17 May 2024

Our reference: 213843

RE: State Significant Development Application SSD-30628110 ‘Summit at Kemps Creek’ at 706-752 Mamre Road, Kemps Creek

Attachment 1 – Detailed stormwater requirements Recommended Development Conditions

2 TYPICAL DETAIL OF STREET TREE PLANTING WITH GROUNDCOVERS IN VERGE  
TYPICAL SECTION  
SCALE 1:20

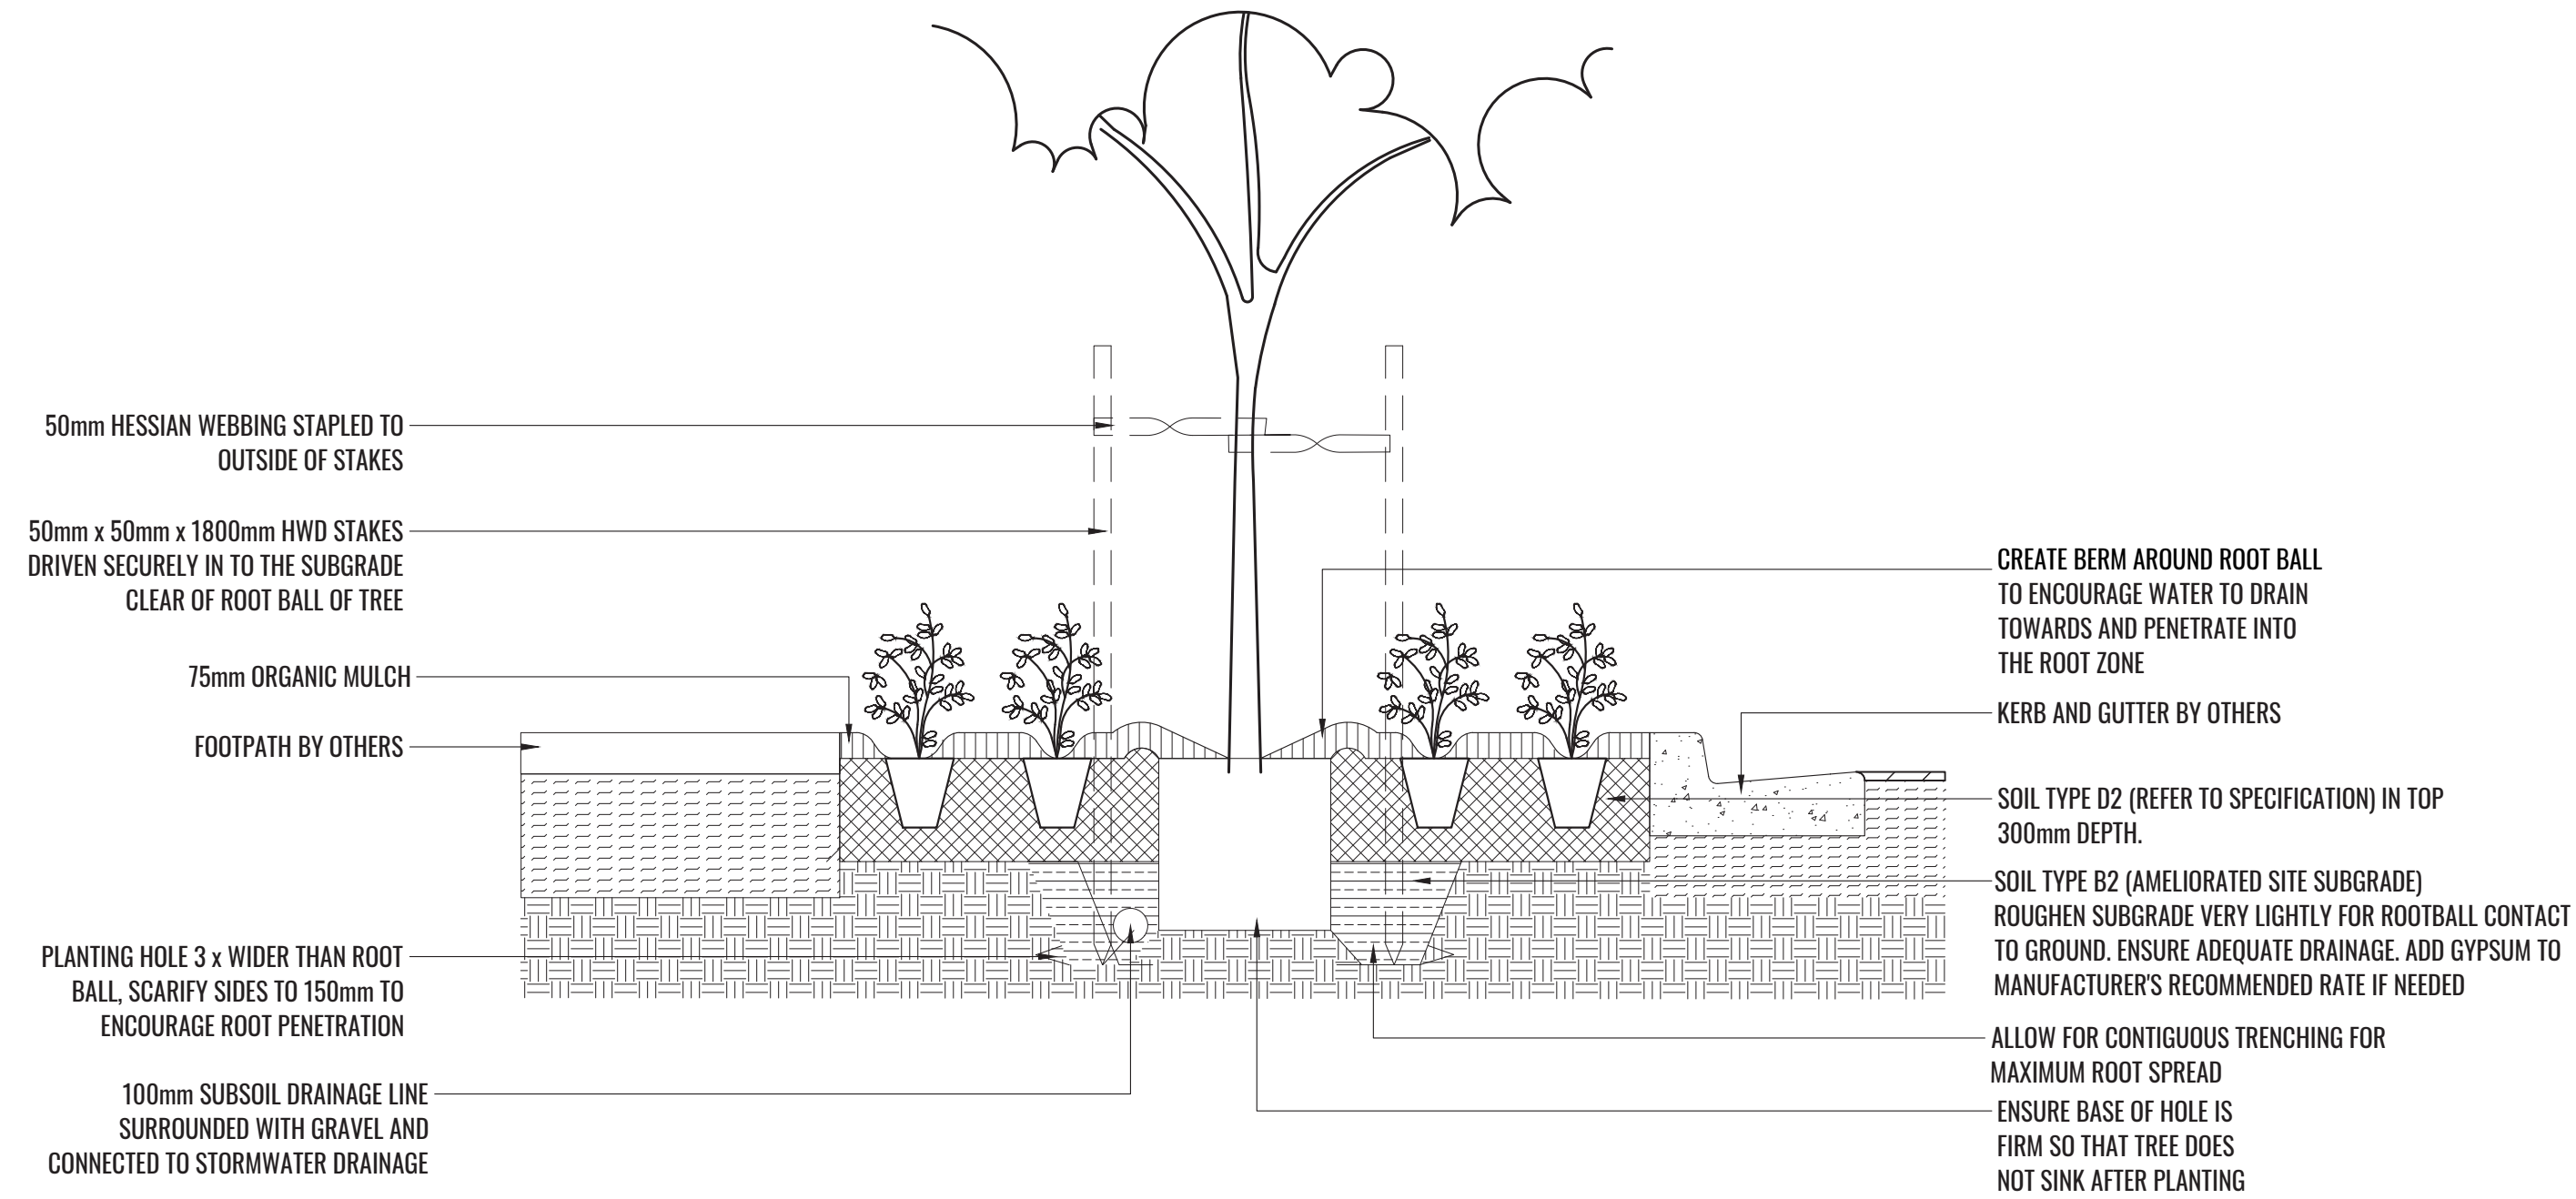
1. Attachment E within the Trunk Drainage Realignment Correspondence isn't clear as to whether the functional levels have been resolved with TfNSW. Has TfNSW provided endorsement regarding the Southern Link Road and Direct Freight Route?
2. Provide street tree planting detail. No street tree detail has been provided in Civil or Landscape package.
3. Cross sections of any known / conceptual service crossings with trunk drainage channels / basins need to be provided.

5 SYDNEY WATER MAMRE ROAD PRECINCT REGIONAL STORMWATER INFRASTRUCTURE DESIGN GUIDELINE: TRUNK DRAINAGE CHANNEL  
TYPICAL SECTION

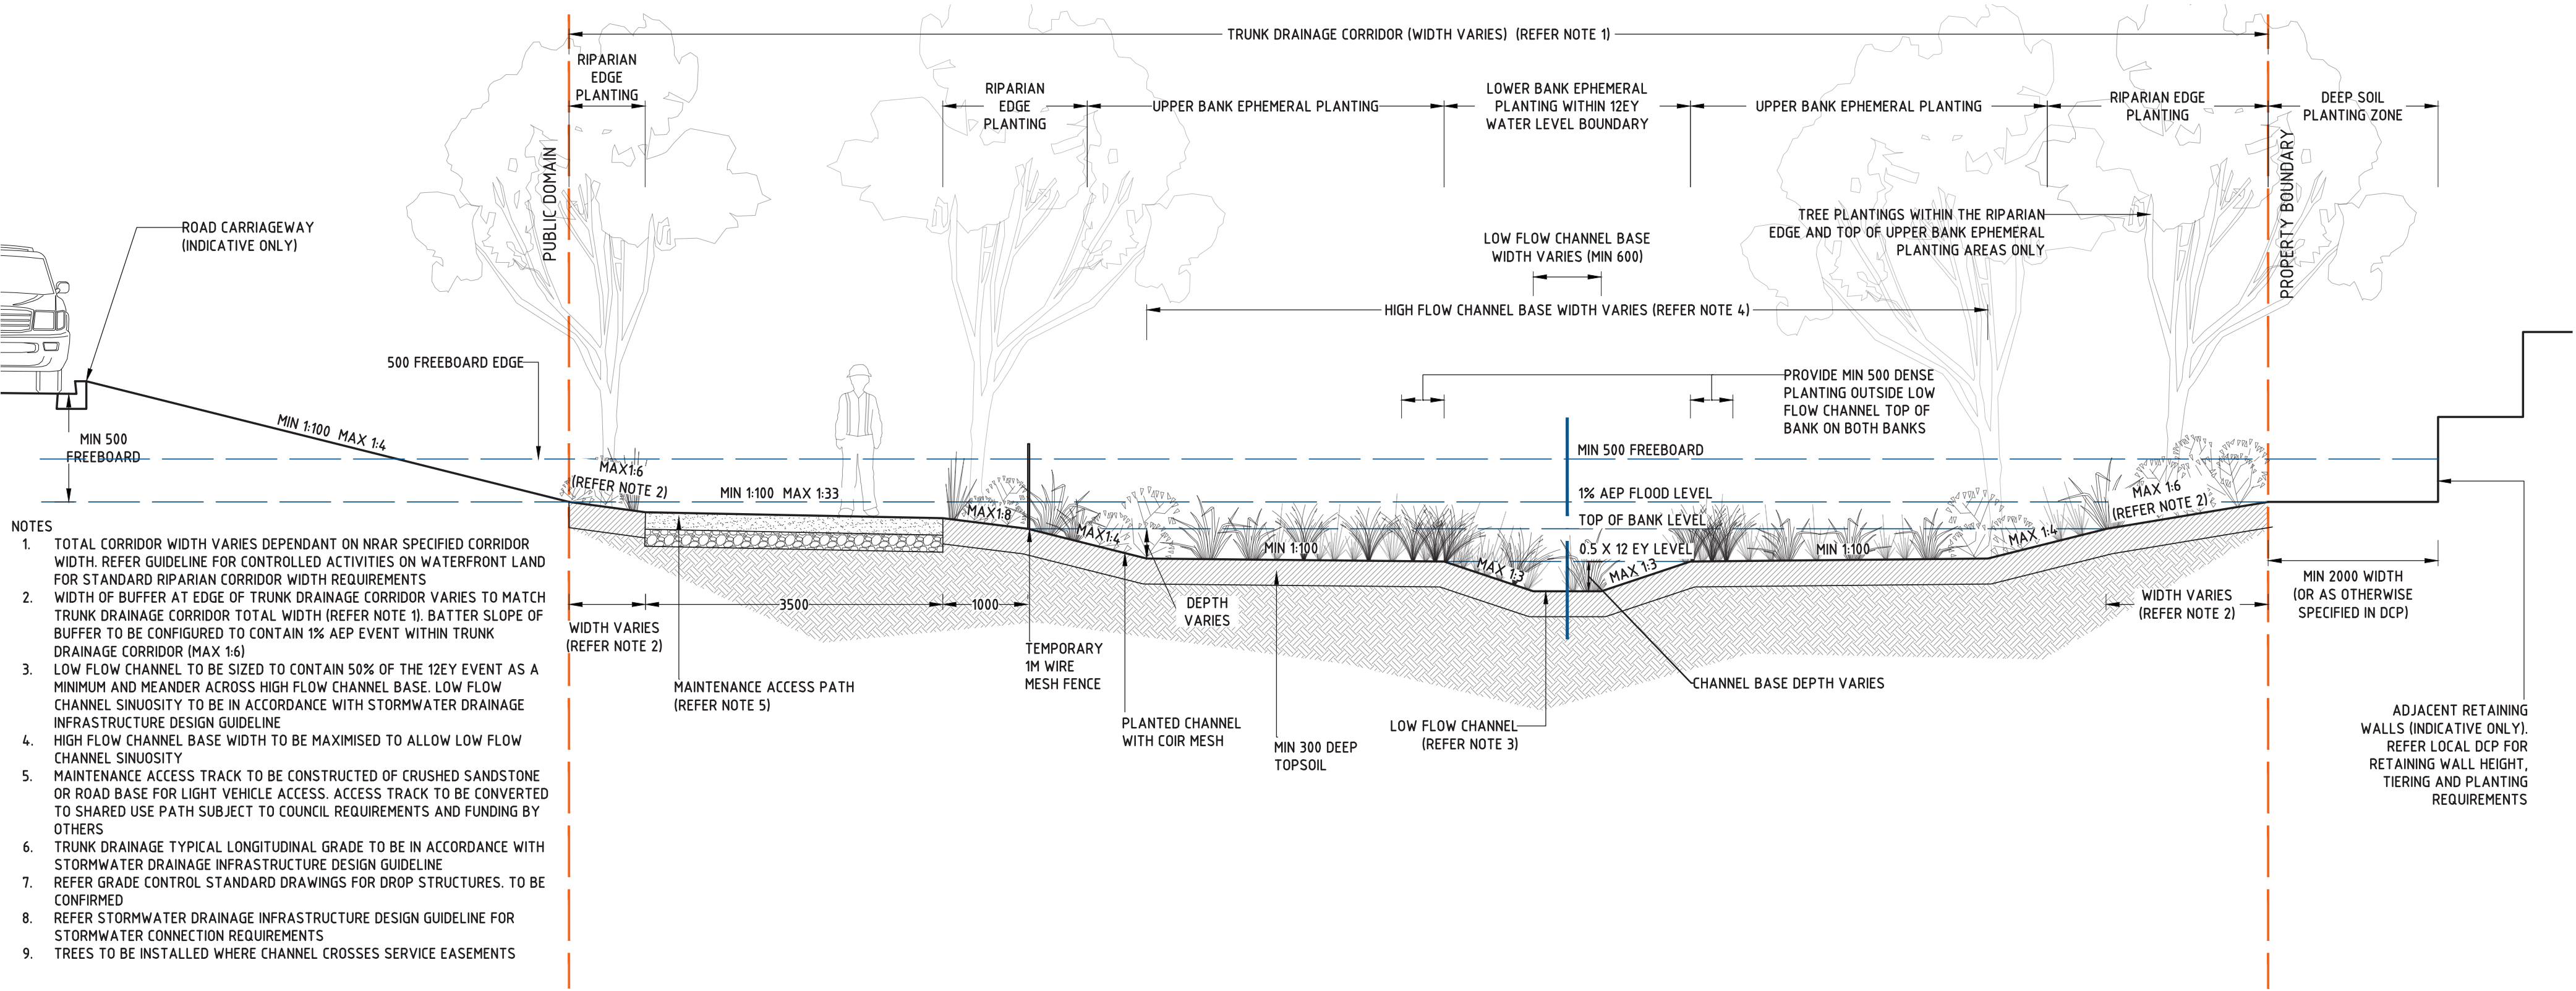
1. The trunk drainage corridor is not represented correctly and is inconsistent with the design guidelines provided in Sydney Water's Draft Stormwater Scheme Infrastructure Design Guidelines (Dec, 2022).

2. The width of the channel is inconsistent with the scheme plan. Sydney Water acknowledges that a reduction of channel width may be supported if consistent with the Sydney Water's Draft Stormwater Scheme Infrastructure Design Guidelines (Dec, 2022) but must demonstrate at a minimum:

- The frequent storm event selected for designing the low flow channel including flow rates and critical velocity.
 - The 1% AEP flow rate is wholly contained within the high-flow banks and maintenance track noting that Sydney Water does not support 1% AEP event inundation of retaining walls (including foundations) in the trunk drainage corridor.

- A minimum 0.5m freeboard is provided to the future Southern Link Road.
 - The proposed trunk drainage corridor width is noted correctly on plan with supporting calculations.

- Provide the frequent storm event selected, 1% AEP and 1% AEP + 0.5m freeboard water levels to give conceptual assurance of the functional design.
- 3. The maintenance track will conform to Sydney Water's Draft Stormwater Scheme Infrastructure Design Guidelines (Dec, 2022) as shown in the Trunk Drainage Channel Typical Plan and Sections. The following comments are made:

- **Sydney Water will not endorse any naturalised trunk drainage channel that does not have a dedicated maintenance access track.**
 - The use of a TfNSW/Council managed shared user path along a road as a maintenance track will not be supported by Sydney Water.

- Include the maintenance track along the full length of the trunk drainage corridor, noting that Sydney Water may support the reduced trunk drainage corridor width subject to the matters raised above.
